Planning Application Ref: WA/22/19/PL

Location: The White Cottage, West Walberton Lane, Walberton, BN18 0QS

Description of works: Demolition of existing dwelling & erection of 1 No. replacement dwelling (amendment to WA/49/18/PL).

Proposed Extension and Alterations
at White Cottage, West Walberton Lane, Walberton
for Mr. and Mrs. A. Wickland
Drawing CD01 March 2019 Scale 1:200 @A3
Planning Drawing - Tree Protection Measures

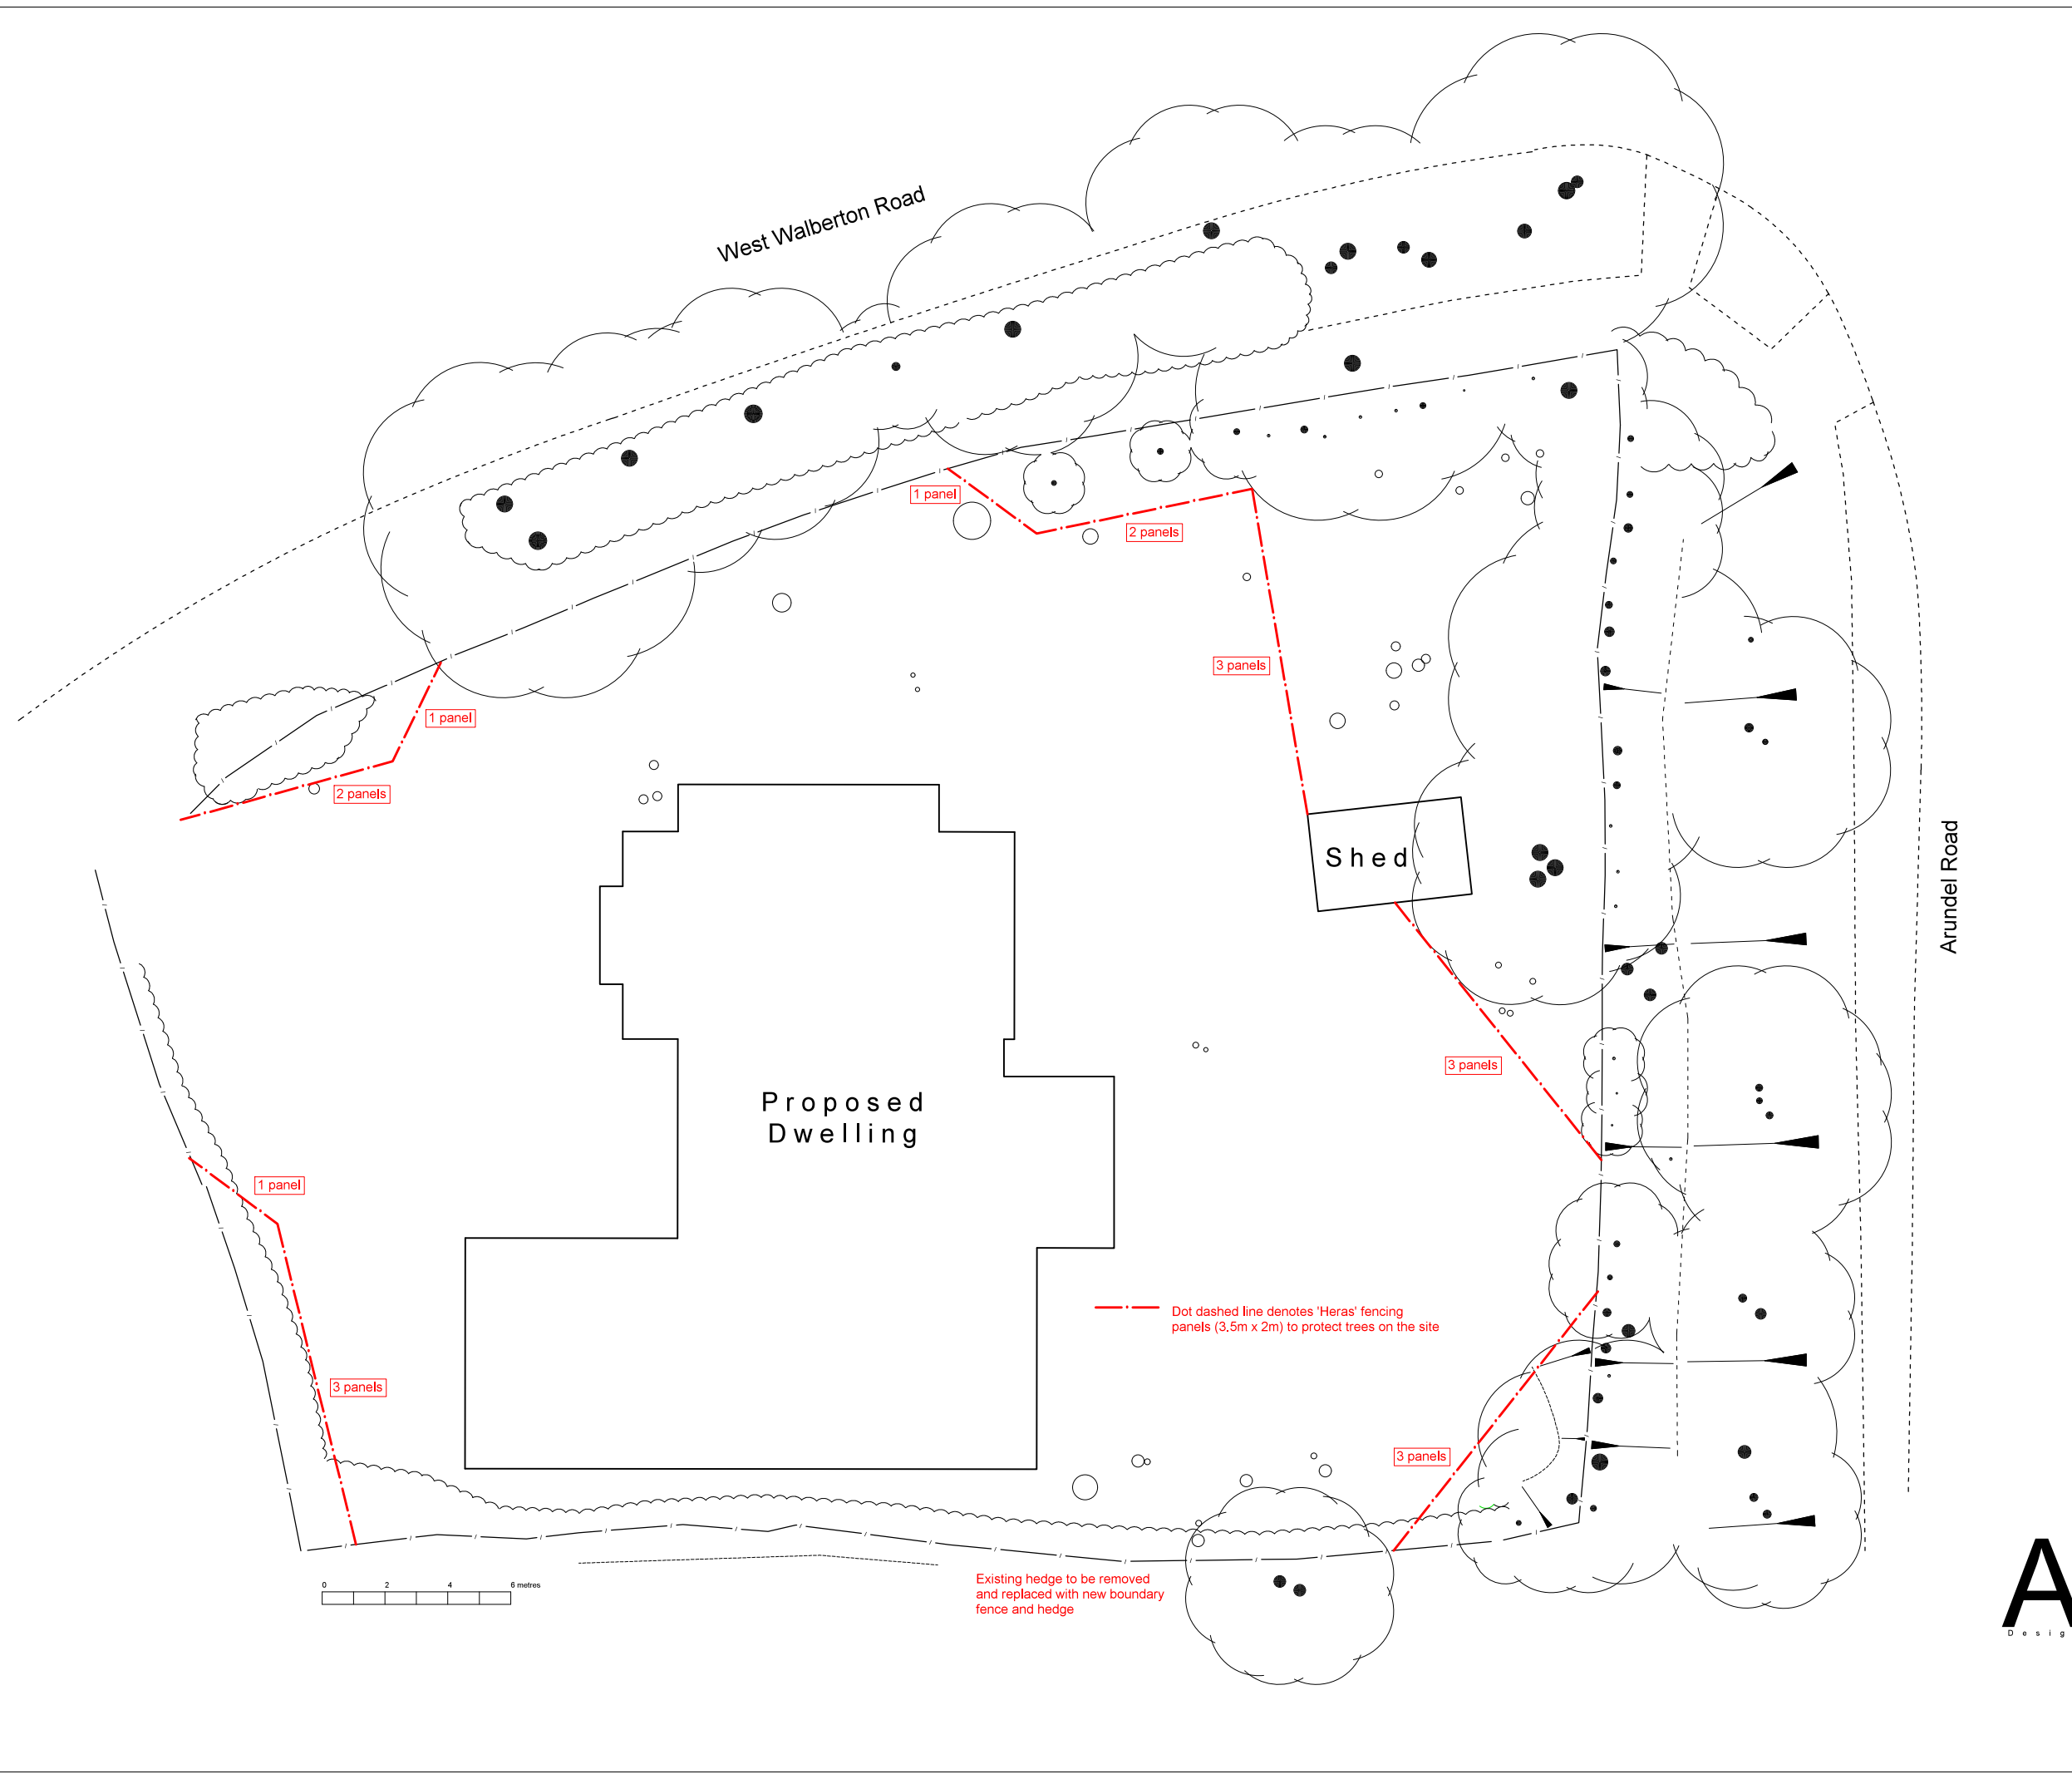
- The sole item of arboricultural information provided, *Planning Drawing – Tree Protection Measures*, dwg. CD01, provided by Architectura, is only indicative of where fencing would be positioned and is not supported by a tree survey and root protection area schedule. This falls a long way short of what is required at this application stage.

- The applicants will need to employ the services of an Arboricultural Consultant to carry out a tree survey exercise and then prepare an Arboricultural Implications Assessment (AIA) which must be inclusive of; a 'Tree Survey Schedule', a 'Root Protection Area (RPA) Schedule' and a 'Tree Constraints Plan' – with the trees accurately plotted on same. [The applicants have employed Honey Tree Specialists Ltd to prepare an Arboricultural Implications Report. The Tree Survey data is comprehensive and accords with the requirements of BS5837:2012. I am in agreement with the retention category ratings for on and off-site trees.](#)

- In the event that a RPA of any tree which is proposed for retention overlaps the development then BS5837:2012 requires that the Detailed Planning Application is accompanied by an Arboricultural Method Statement (AMS) and also most importantly a Tree Protection Plan – to both describe and illustrate the mitigation measures which are to be employed to ensure that the trees survive without detriment to their vigour and vitality and are given adequate protection both above and below ground. [The applicants have employed Honey Tree Specialists Ltd to prepare an Arboricultural Implications Report that is inclusive of a Method Statement and Tree Protection Plan for this project.](#)
